TR010034 – A57 Link Roads

Preliminary Hearing Tuesday 16th November

I seek greater clarity regarding the derivation of the traffic model data, to assist my further written representation. Accordingly I submit this question of clarification to the Examination Preliminary Hearing.

Drawing Title: **FIGURE 15.1 COMMITTED DEVELOPMENTS**

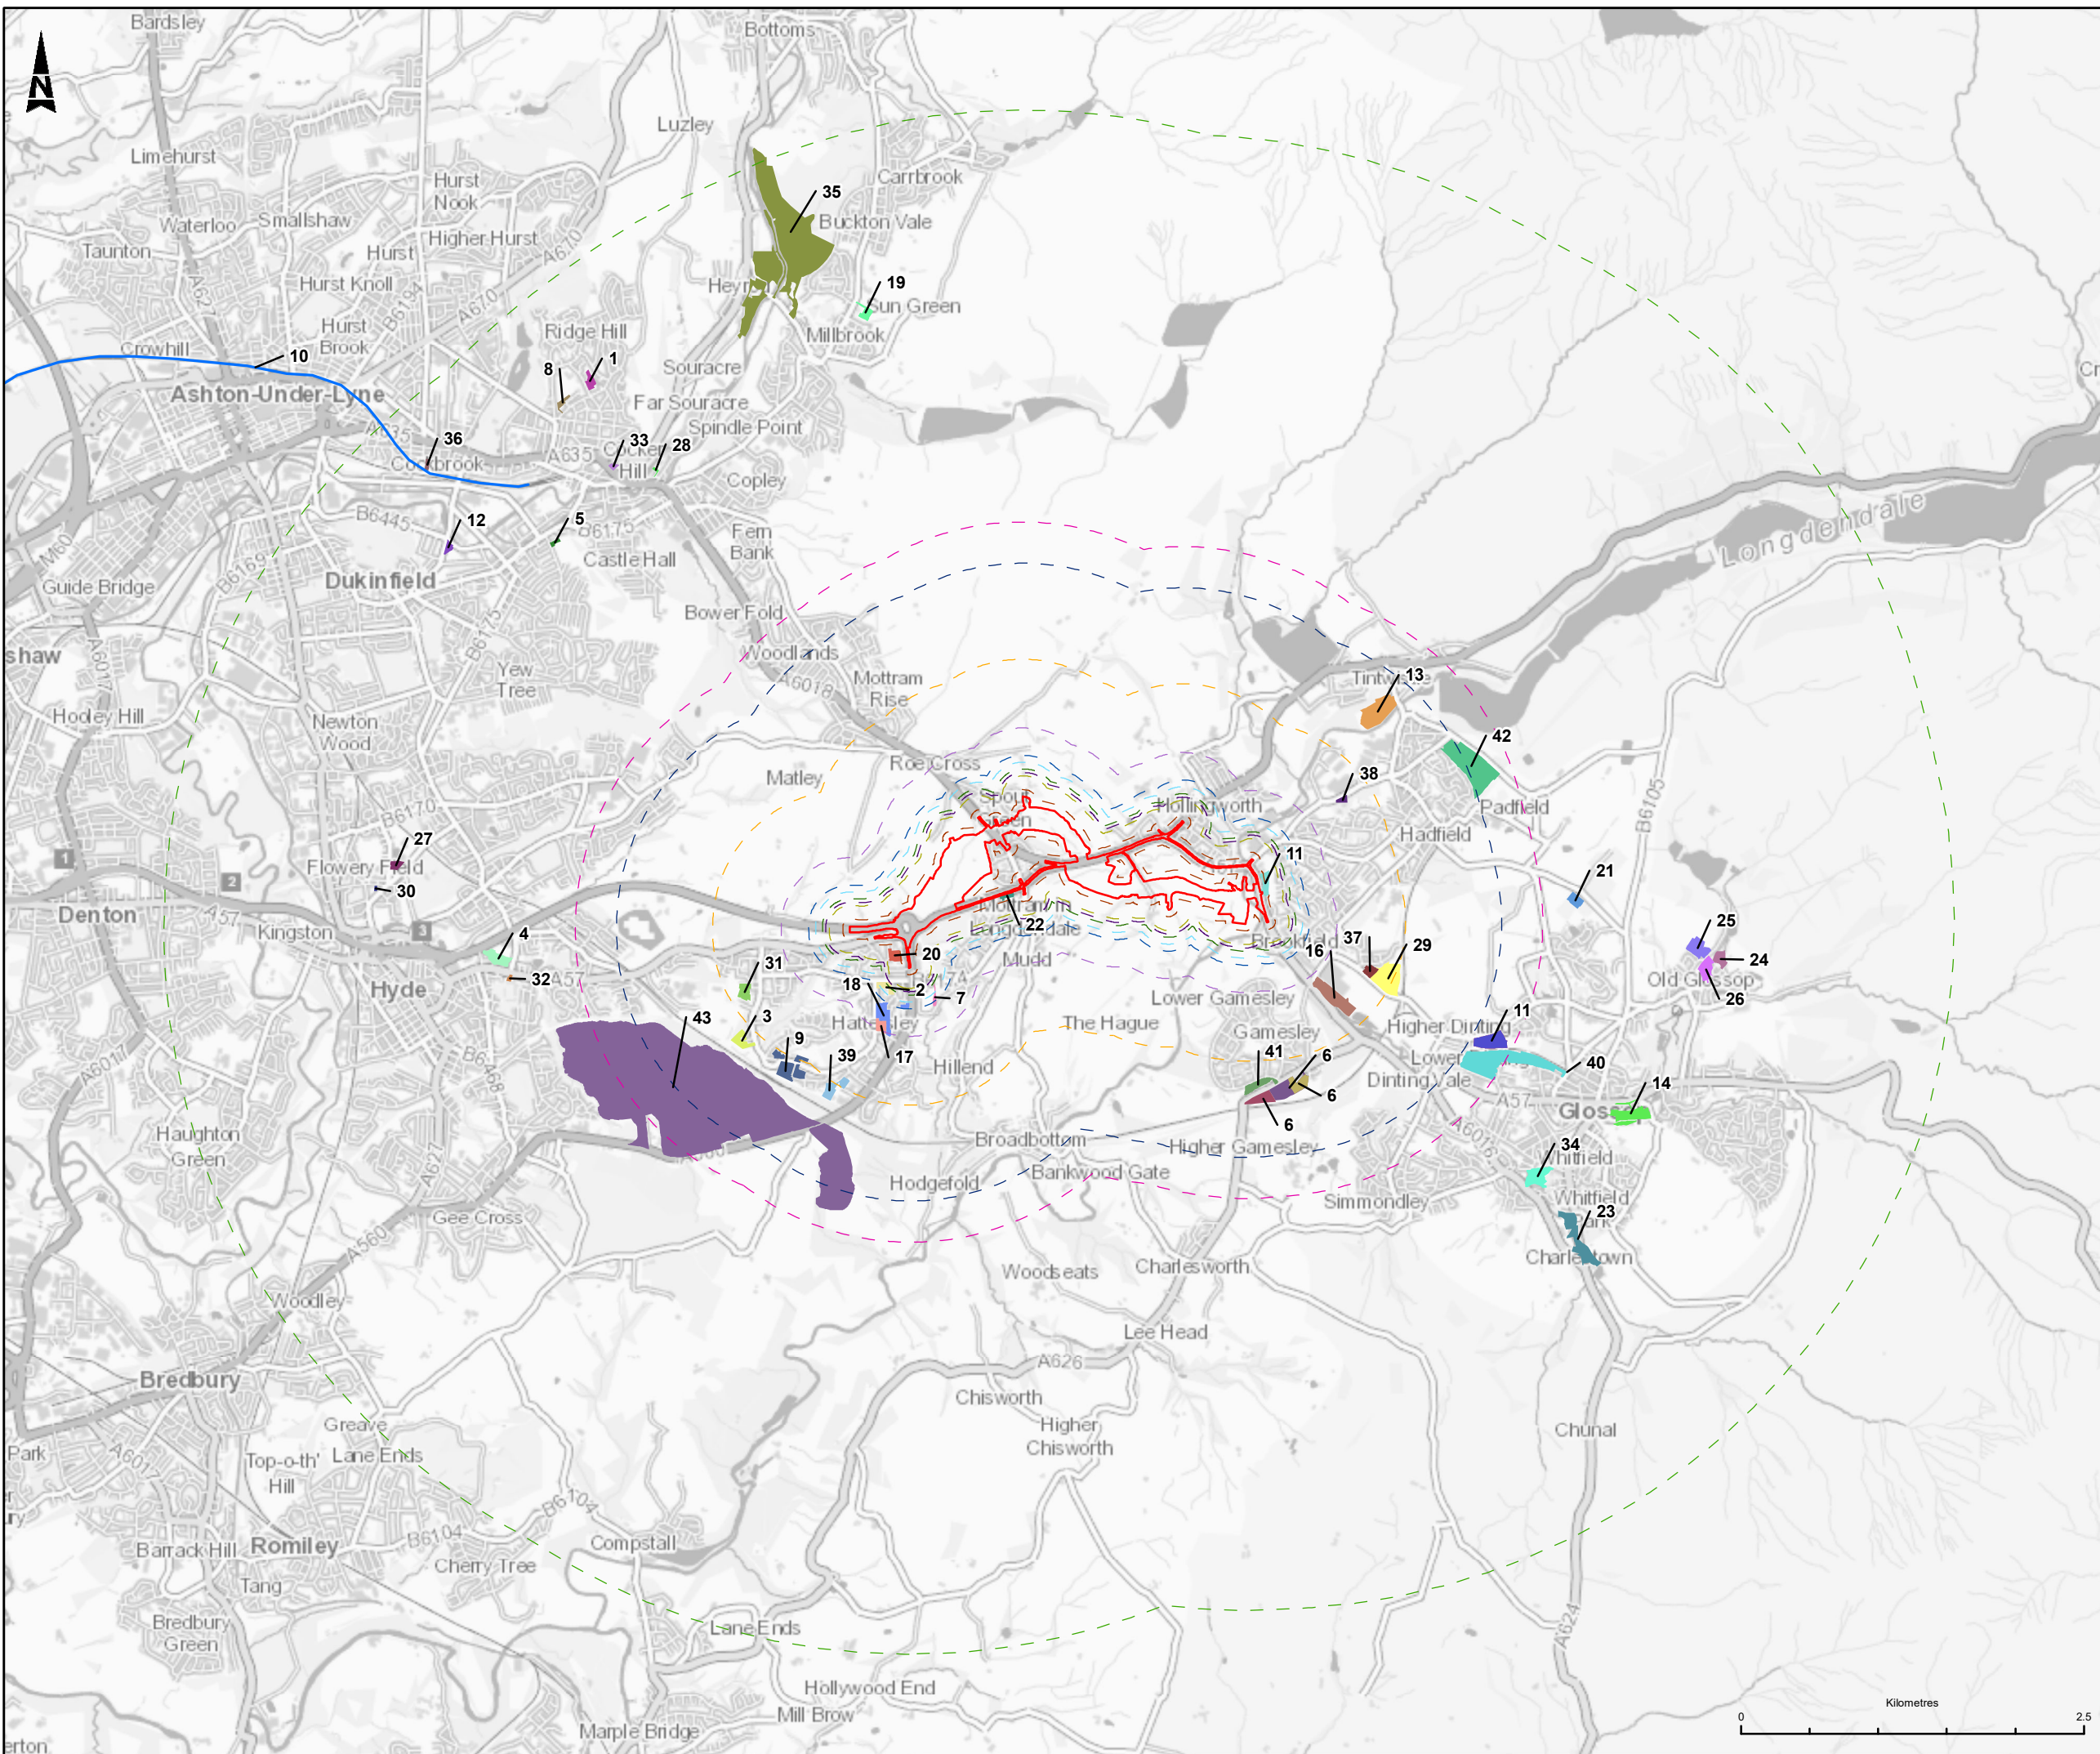
"It is not clear what percentage of the promoter's modelled traffic data accounts for that generated by the "committed developments" (ES 6.4 Figure 15.1). Can the promoter Highways England please supply that figure both generally; and particularly with regard to the Glossop and High Peak figures? (HE Appendix 2.1 Inserts, 2, 3, and 11)."
